9th November 2018

Two-storey extension to the existing Cafe in order to provide increased internal seating, multi-purpose space, with improved service & food preparation area, disabled access & bike storage.

The Bluebird Cafe South Drive Ferring

Thank you for your internet comments made on 8th November 2018 which has been recorded as **'an objection'** with the comments as follows:

02 Proposed Site Plan
1002 Scale: 1:200

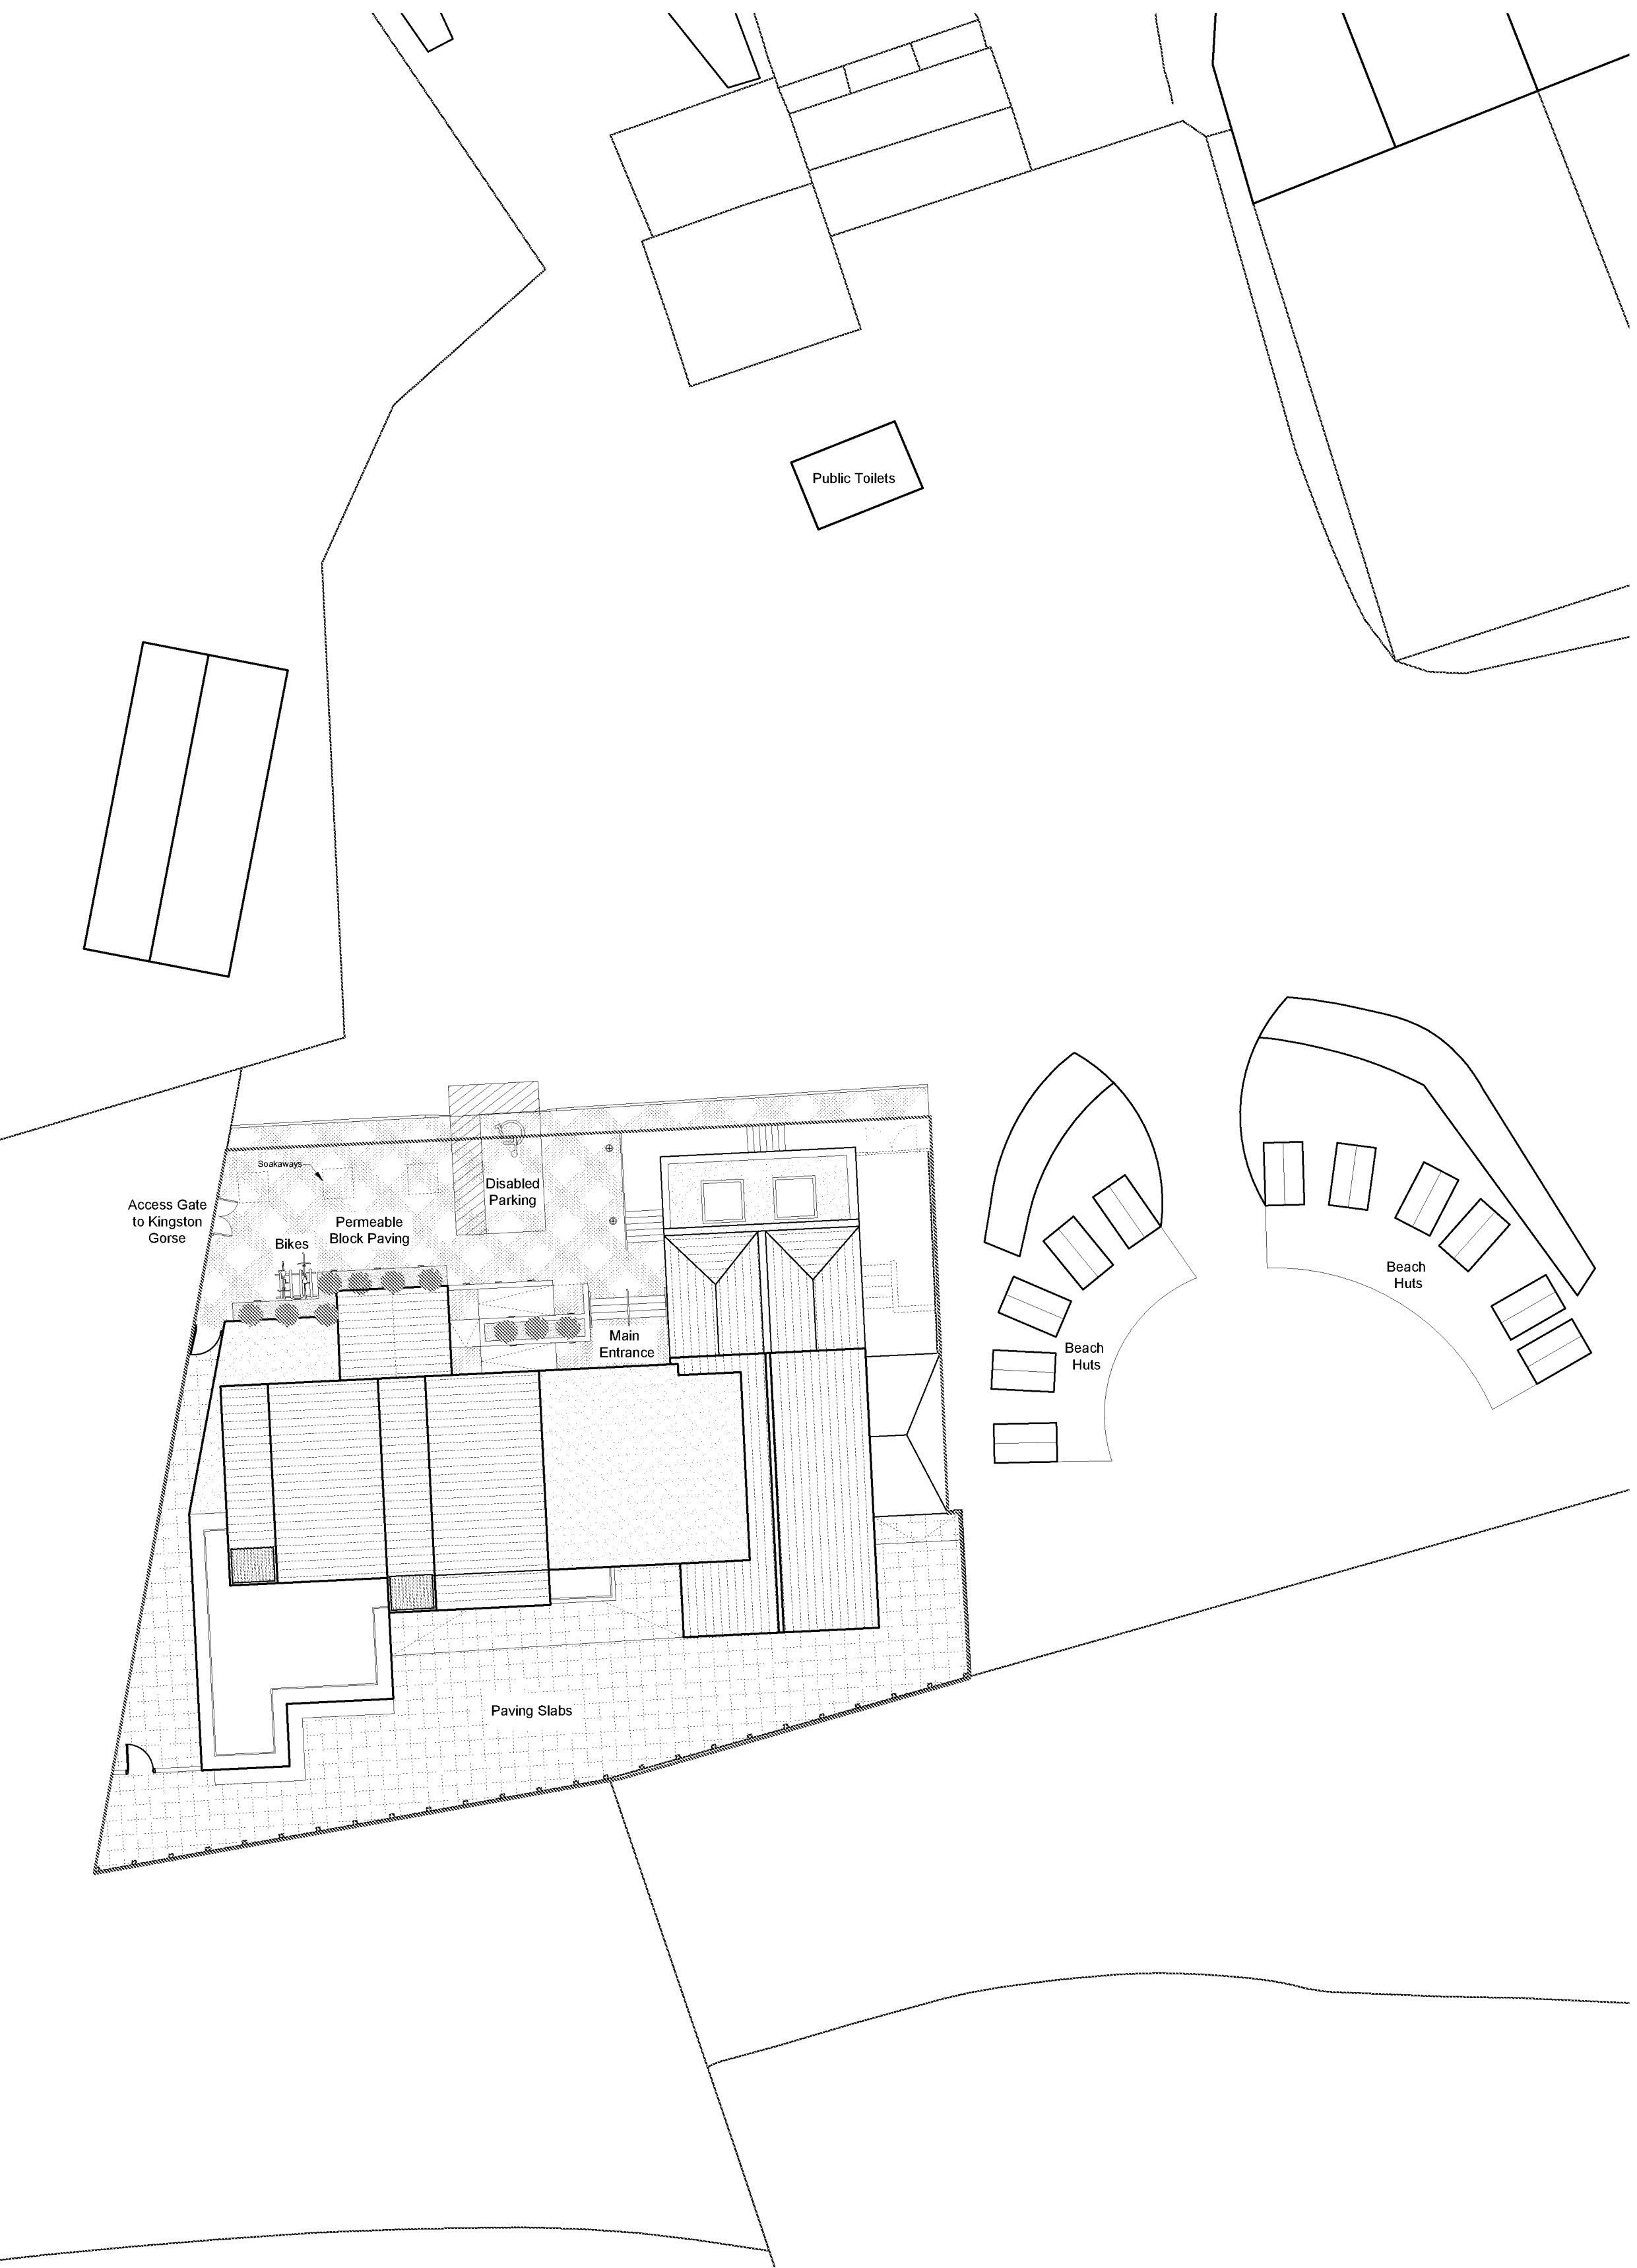
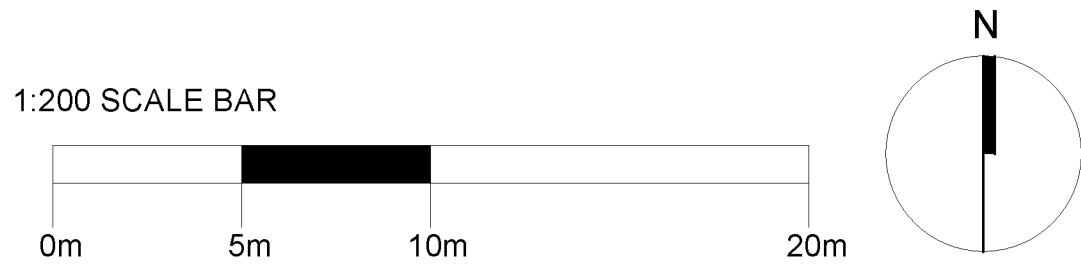
(vii) The access driveway/footpath width combined is approx. 3.5 to 3.6 metres and in the region of 170 feet long. For its entire length it is edged by high walls providing no area of safe retreat in the event of conflict for space with vehicles. There is no delineation (either physical or in terms of ground markings) between the vehicular space and the Public Footpath

(ix) The splay of the entrance /exit should also be assessed as it does not conform with line of sight conditions imposed on other sites. Visibility to the right for traffic emerging from the site's access driveway onto the Private Street is severely restricted.

(x) The junction of the driveway access onto the private street is also the location of a bus stop.

(xi) The ground surface conditions of the uncontrolled car park area are in poor condition, deeply rutted and potholed gravel and compacted soil. There are no defined parking bays and parking is subsequently haphazard and on a free-for-all basis. Access across this area

is required for delivery vehicles servicing the café, vehicles servicing the public toilets, refuse collection and by the Environment Agency to access the Ferring Rife (river) weed-screen for cleaning / maintenance as well as being the only vehicular access at this point to the beach for emergency vehicles. There are multiple owners of the land forming the car park.
